RE: **Lot 17 Block 6 SAD 228**
Volcano Cliffs Subdivision Unit 19
6309 Vista Del Prado NW
Grading and Drainage Plan
Engineers Stamp Date 3/29/2020 (D10D003F17)
Pad Certification Date 4/26/2020
CO Certification Dated: 12/10/2020

Based upon the information provided in your submittal received 12/14/2020, this plan cannot be approved for Certificate of Occupancy until the following comments are addressed.

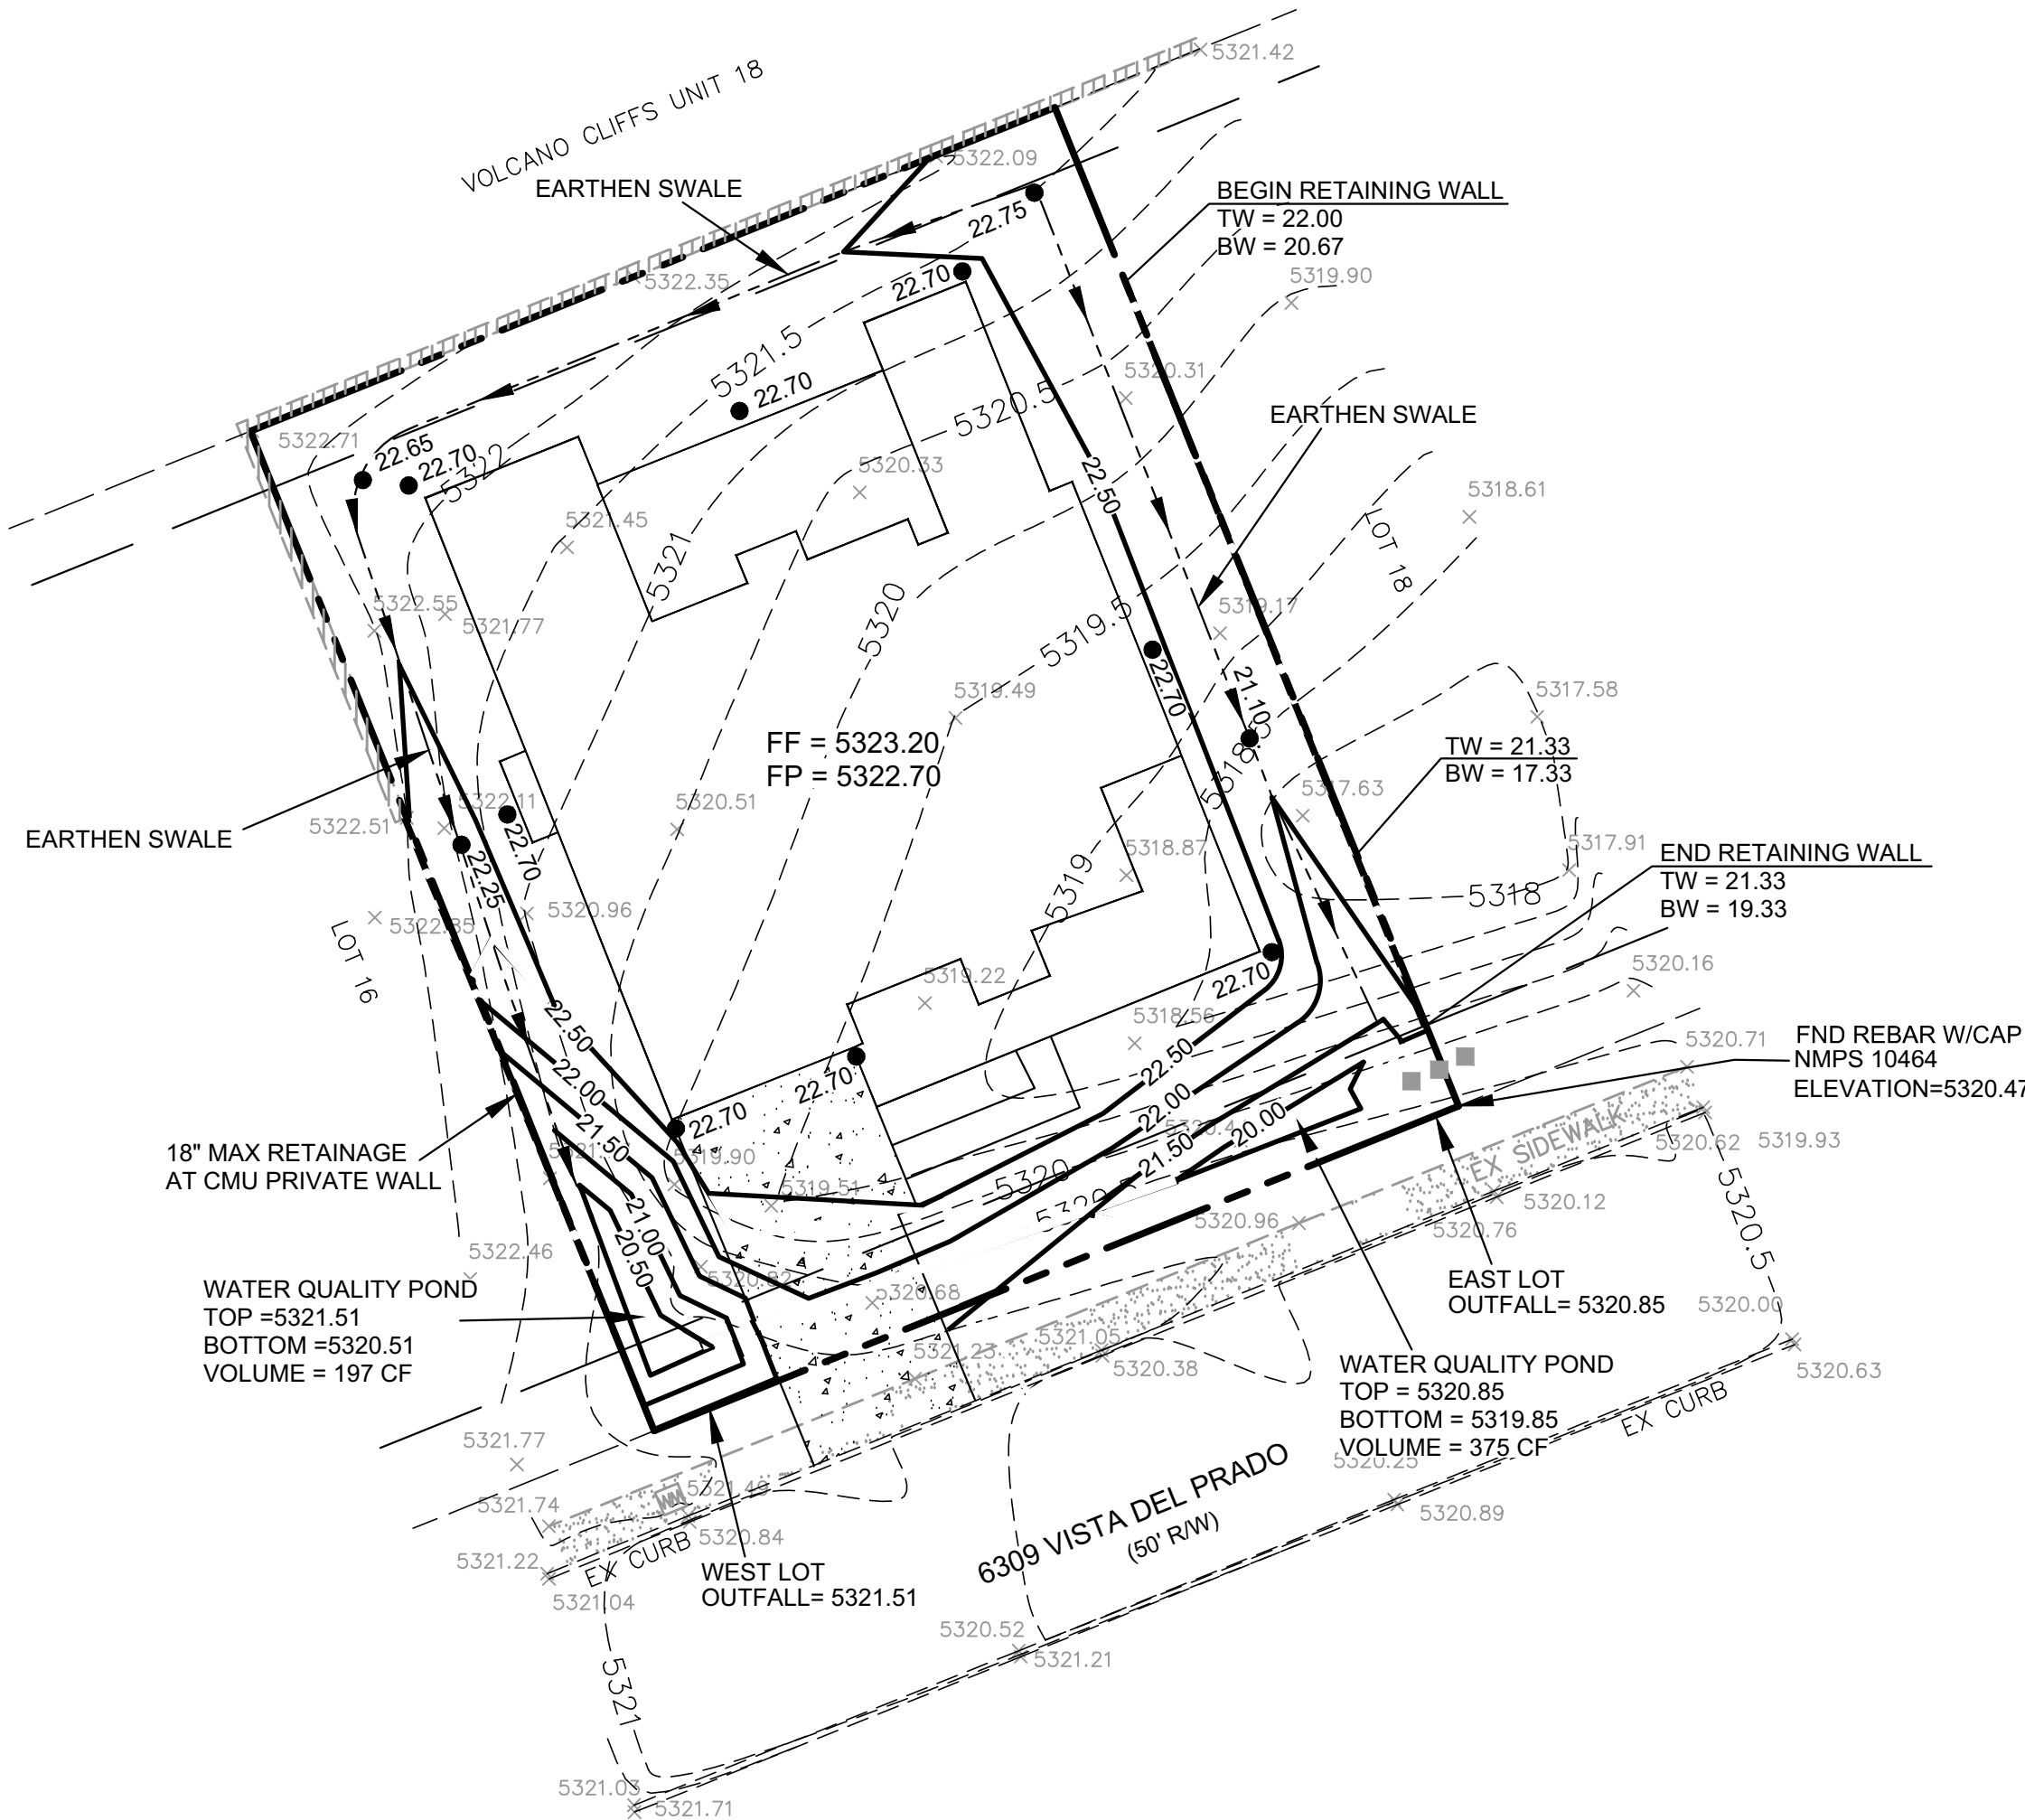
- South side yard and rear yard not following G&D plan. Concrete placed not allowing flows to exit into front yard.
- North side yard missing swale directing flows to front yard.
- Wire trash pen in neighbor's yard, out house in neighbor's yard.
- Pond in SE corner of yard smaller than proposed.
